Ribble Valley Borough Council
Housing & Development Control

Application no: **3/2020/0595**

Address: **88 Fairfield Drive Clitheroe BB7 2PS**

Proposal: **One and a half storey side extension and an extension to existing rear dormer and proposed dormer to front.**

Ground Floor Plan

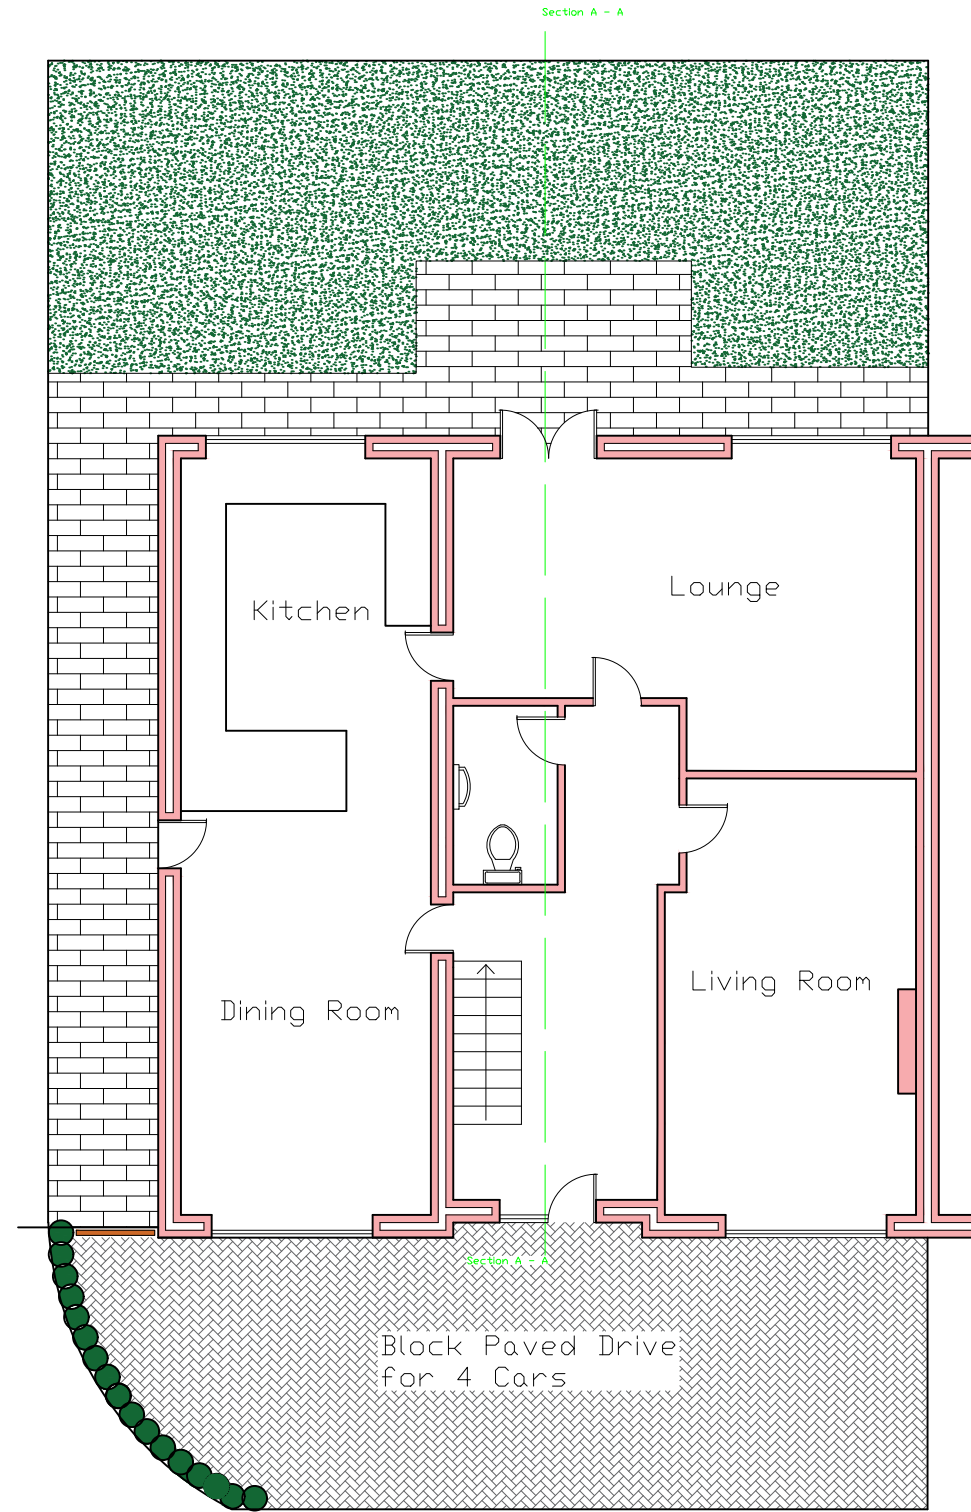
The proposed extensions and alterations will involve an increase to the existing number of bedrooms from three to four, resulting in an increase to the existing parking provision, from two to three parking spaces and whilst the applicant has demonstrated how they intend to accommodate the increased parking provision within the curtilage of their property, the proposed parking layout would not be considered acceptable.

The proposed parking layout as proposed illustrates a small boundary treatment in the form of a hedgerow to the eastern side of the property, in proximity with the road junction for Fairfield Close, there are a number of constraints at the radius where the hedgerow is proposed in the form of a street lighting column, a telegraph pole and street signage and whilst the local highway authority would raise no objection to the principle of the development proposal, the current parking layout as proposed would raise highway concerns that could have a detrimental impact on highway safety.

Furthermore, the proposal will involve both a new vehicular dropped crossing point being installed, and also an existing vehicular dropped crossing point being reinstated to full kerb height. These works can only be carried out by LCC as the local highway authority under Section 184 of the Highways Act 1980.

However, should the applicant wish to provide three perpendicular parking spaces fronting the dwelling with an overall width of 7.8m starting from the adjoining property then the local highway authority would be more supportive of the proposal.

I ask the plans are revised.
